Our Ref: F2025/00890
(Contact Officer: Joseph Edmonds, ph: 9093 6955)

Reference number	SSD-81426710
Subject Land	138 Maroubra Road, Maroubra
Proposal:	Construction of a nine-storey mixed-use development comprising a residential flat building and ground floor retail premise, including: - 27 x 1-bed apartments, including 7 affordable dwellings - 14 x 2-bed apartments, including 6 affordable dwellings - 23 x 3-bed apartments - Communal open space at rooftop level and on level two Replacement of an existing single level of basement to provide basement car parking, plus additional parking provided above ground on the first storey. The application is seeking an infill affordable housing bonus under the SEPP Housing 2021, noting that 13 affordable housing units are proposed within the scheme.

I refer to your request for Council's review of the Mixed-use development with in-fill affordable housing at 138 Maroubra Road, Maroubra. The following comments are provided for your consideration.

140 MAROUBRA ROAD (PACIFIC SQUARE) /
BALCONIES COLOURED RED
SUBJECT SITE (BLUE)

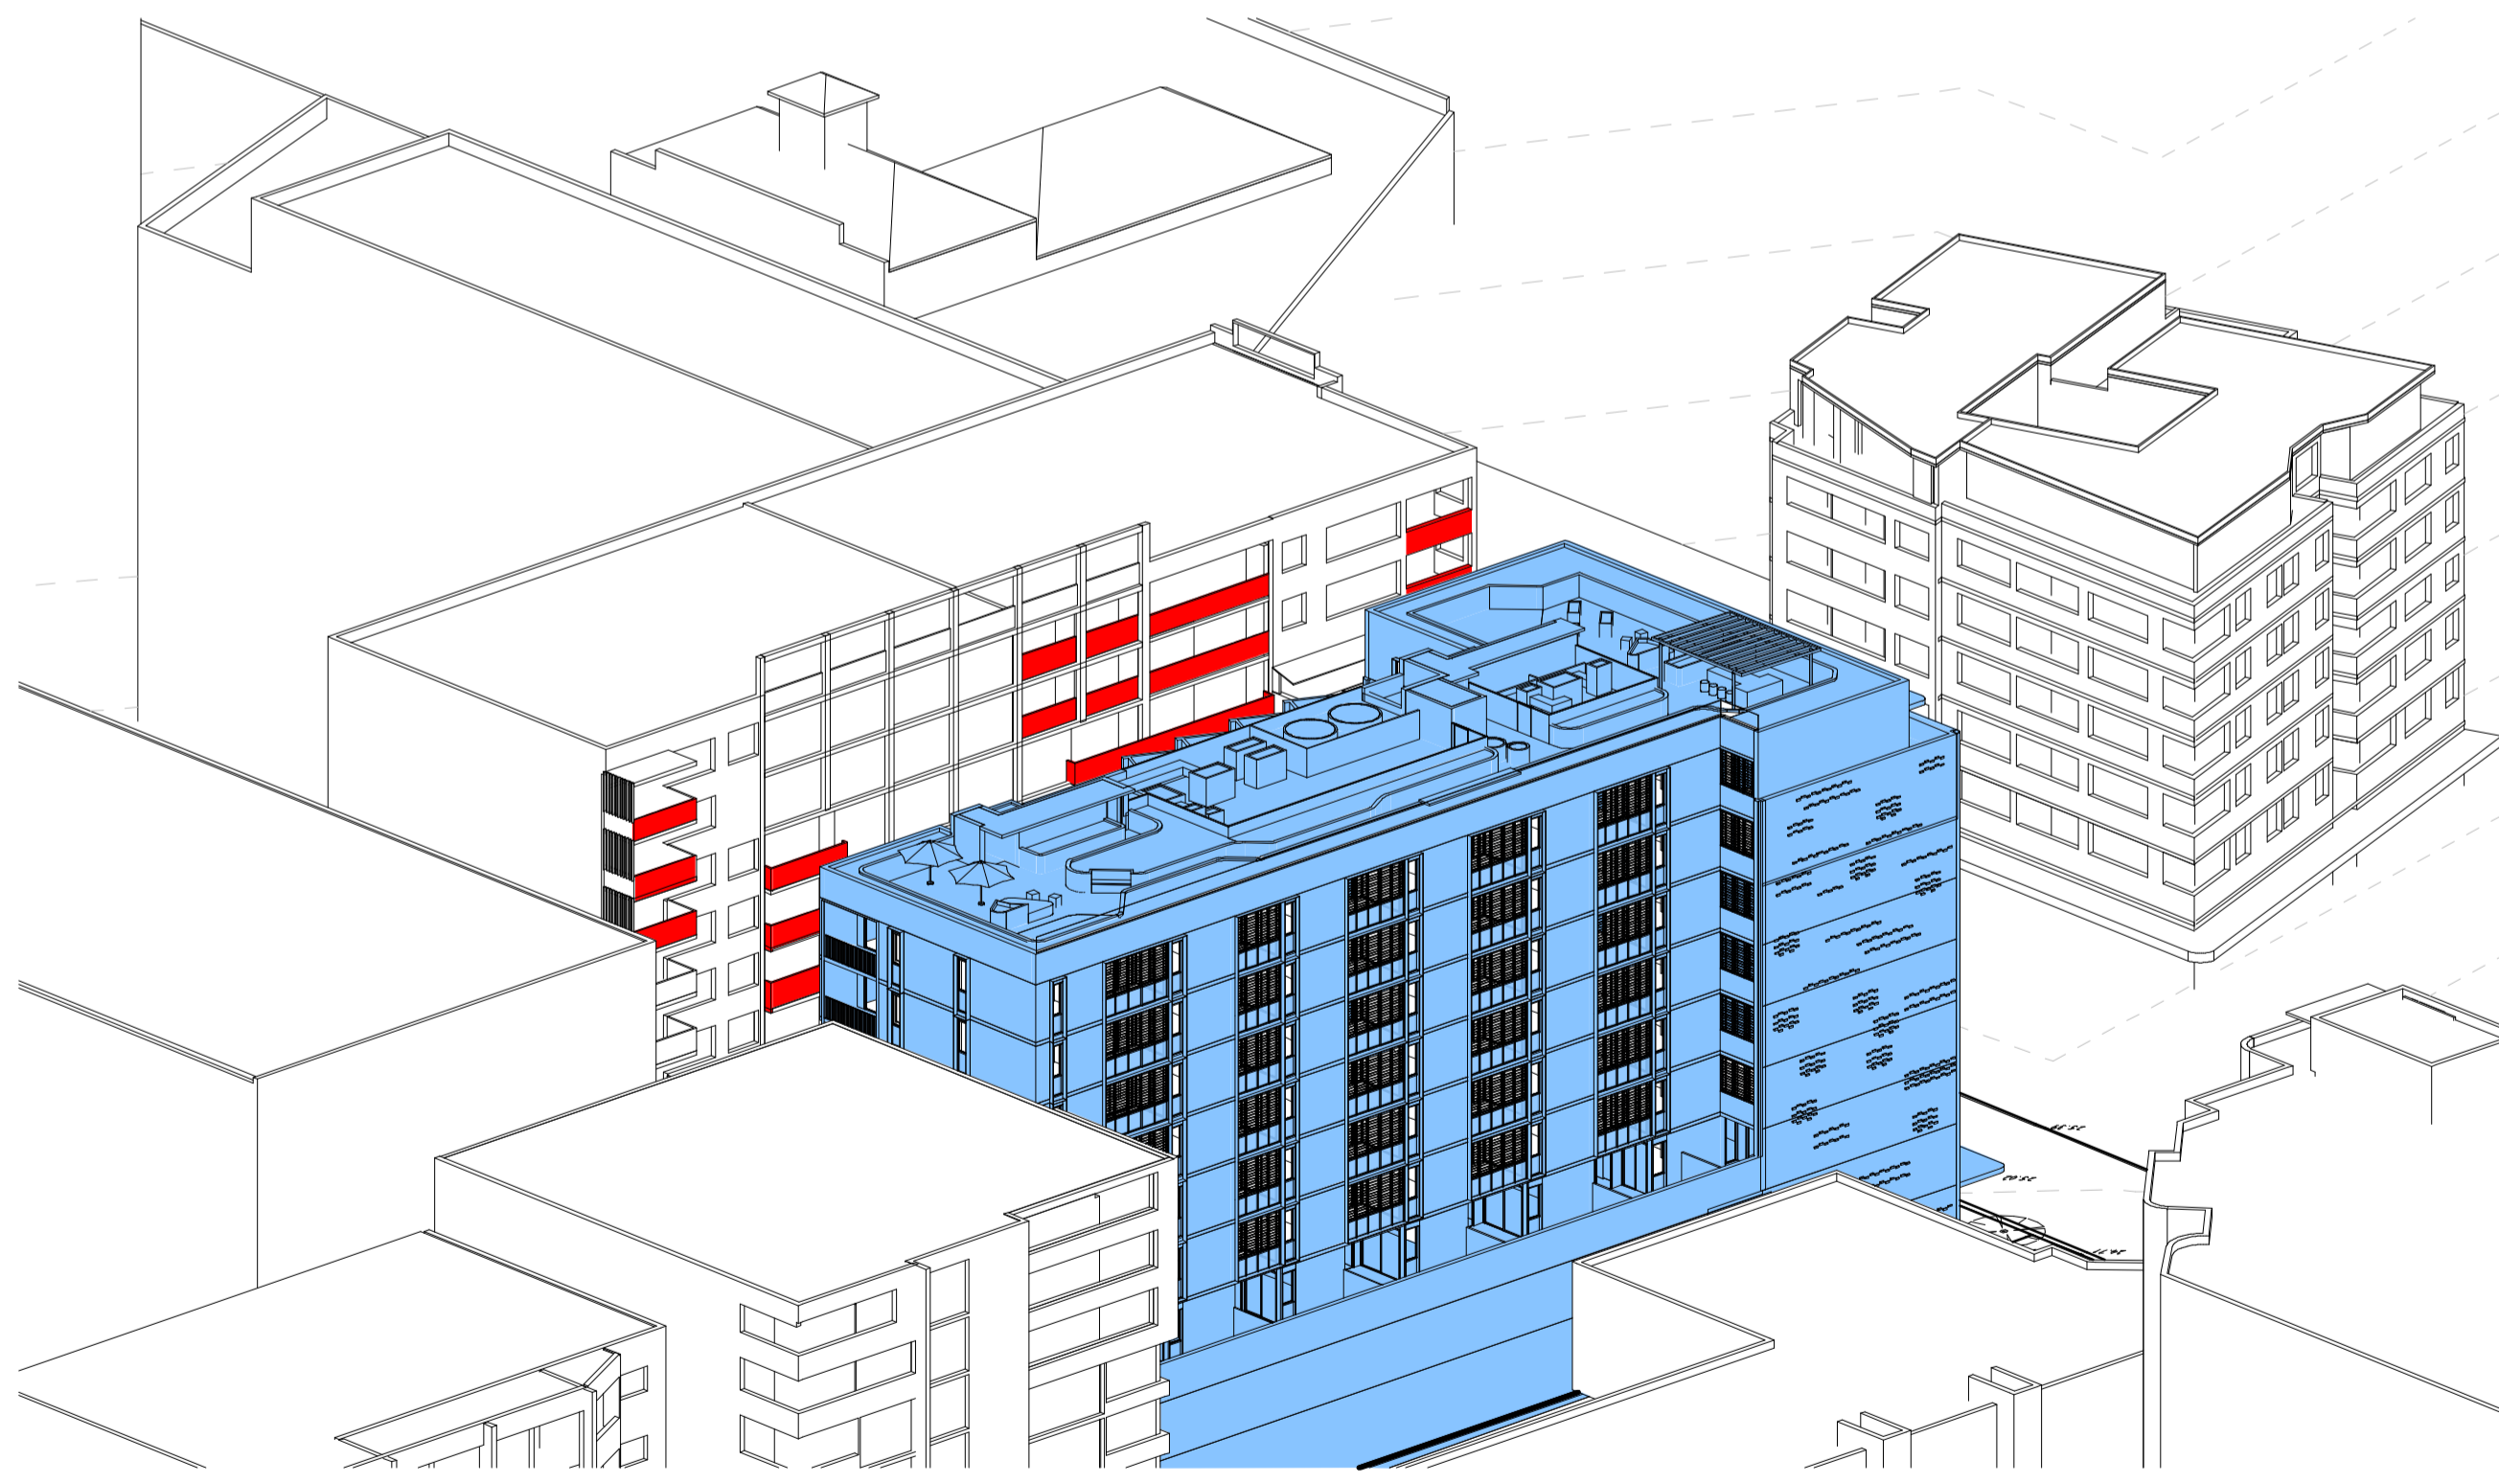
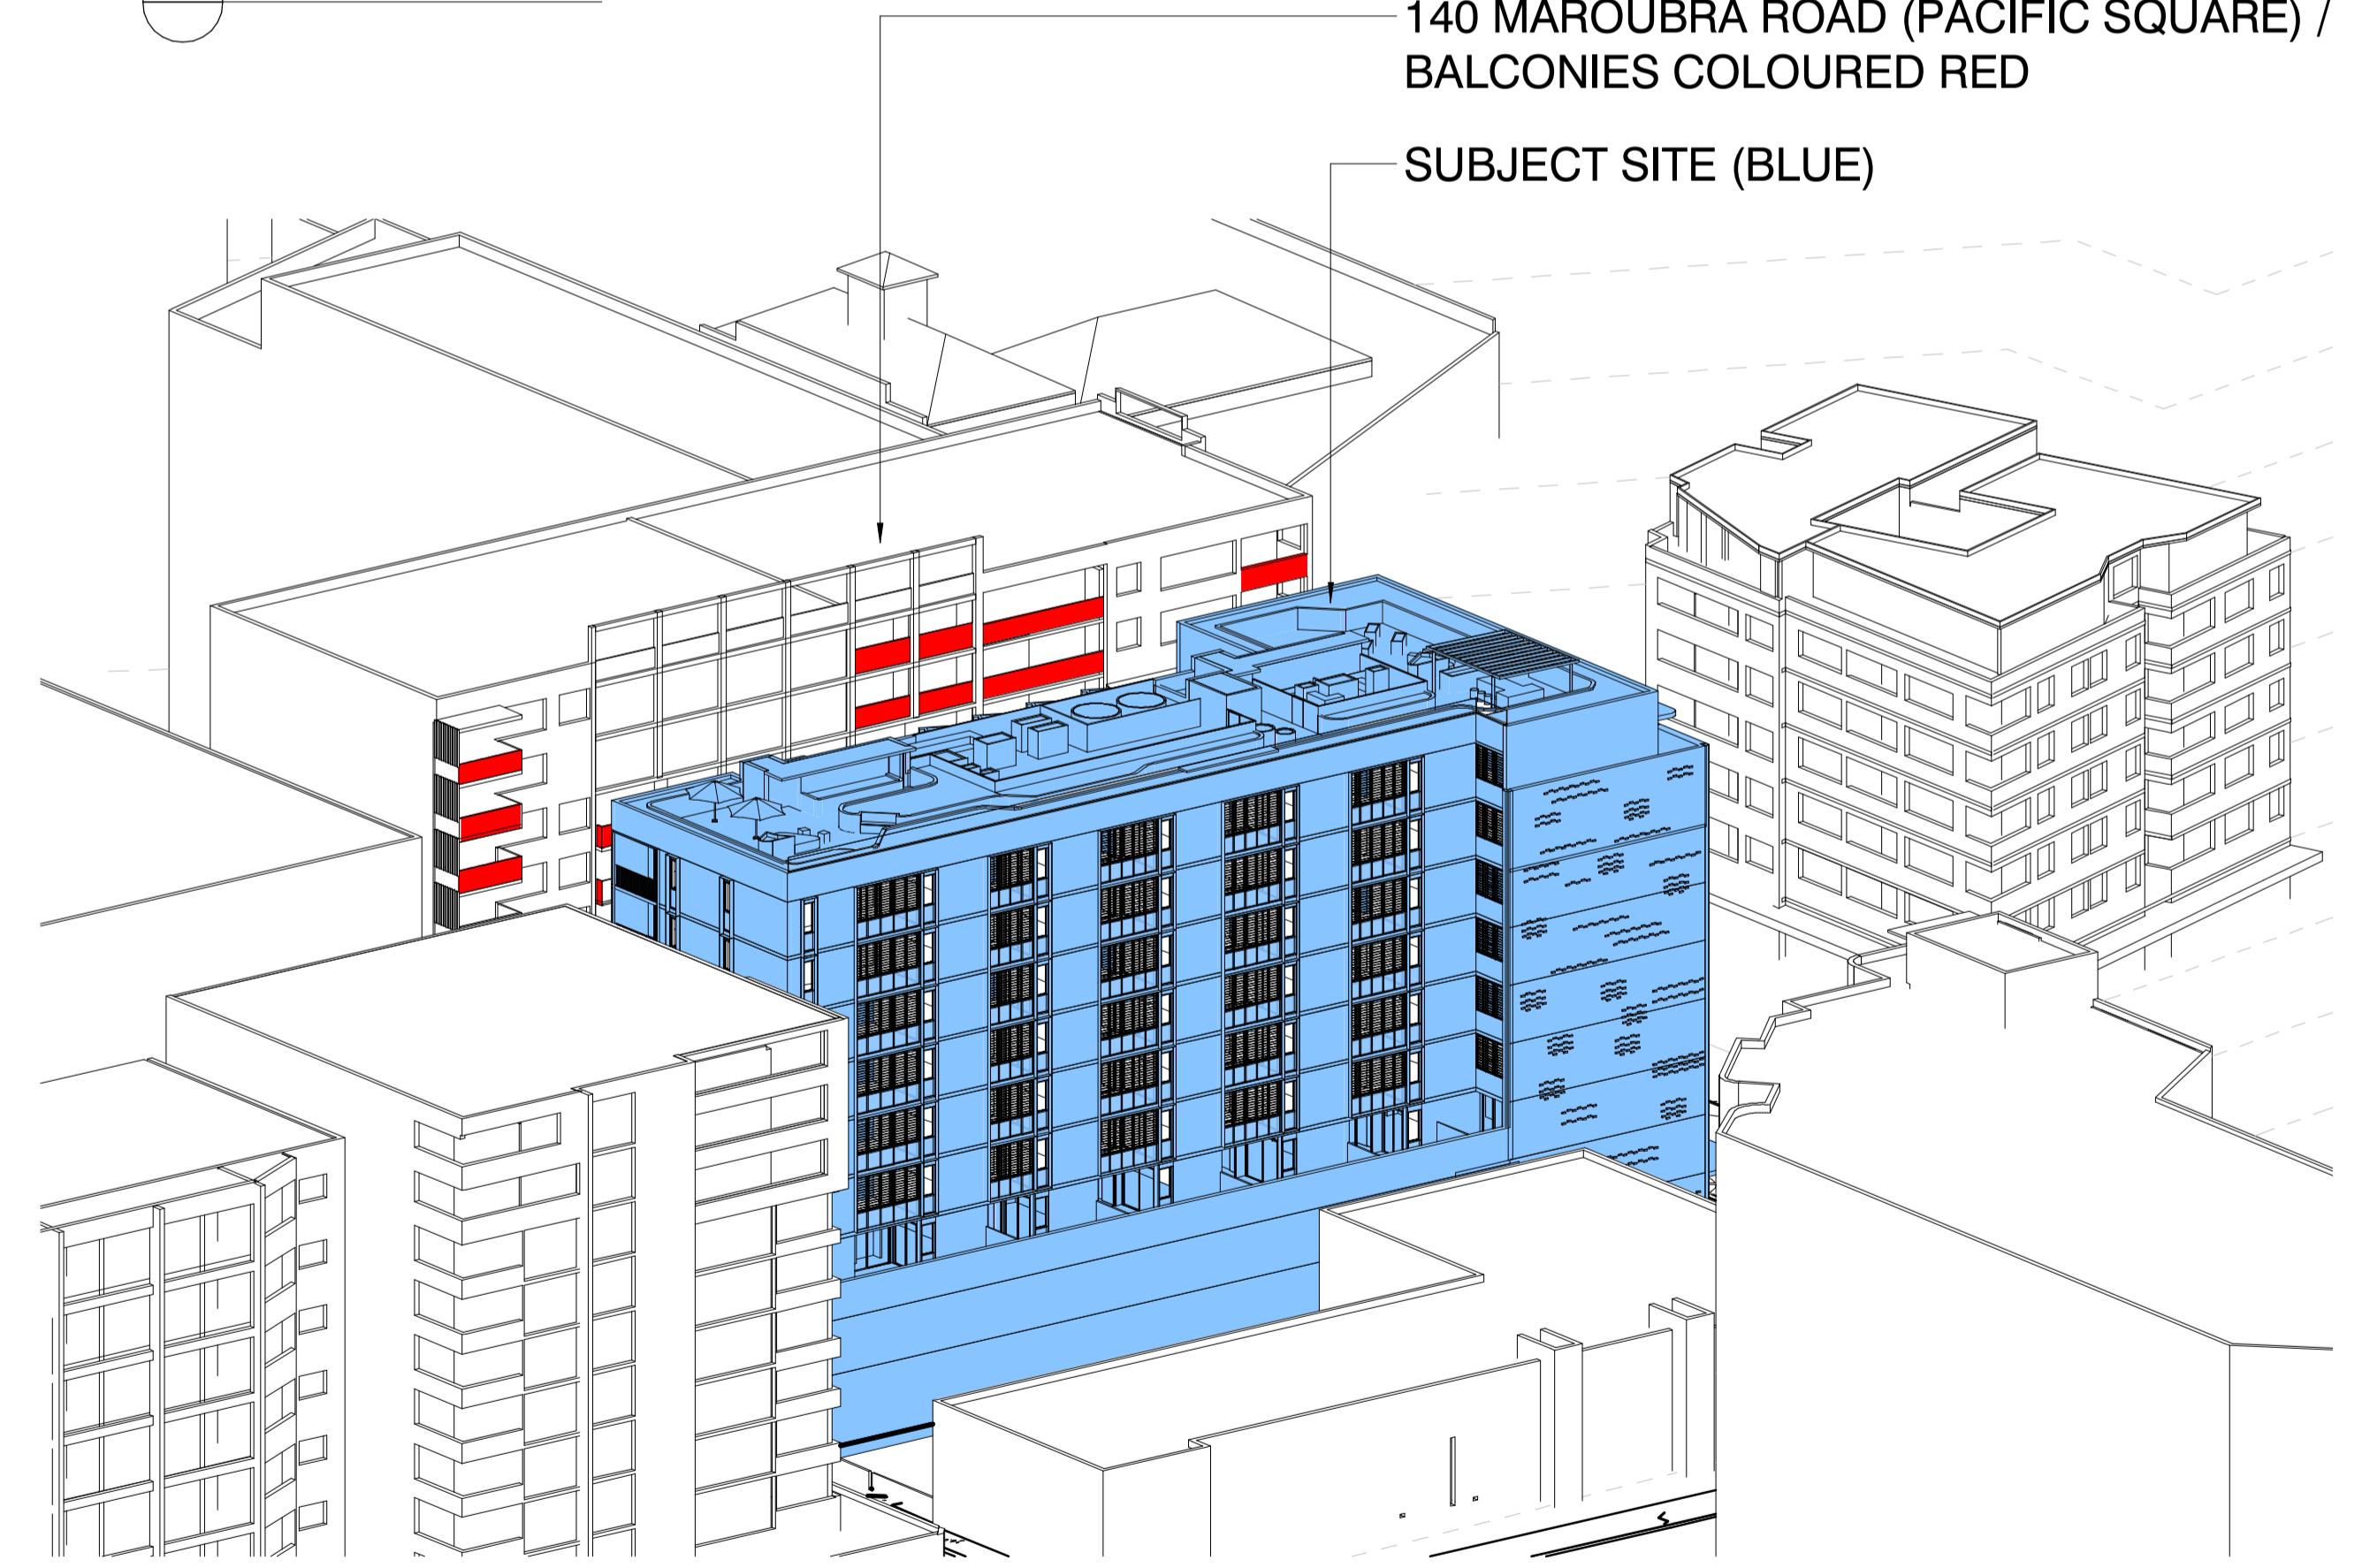
As shown in the Eye of the Sun Diagrams much of the development will not receive sunlight in the case of a similar scale redevelopment of the Police Station to the west and that sunlight access would be predominantly lost from 1:30pm to 3pm.
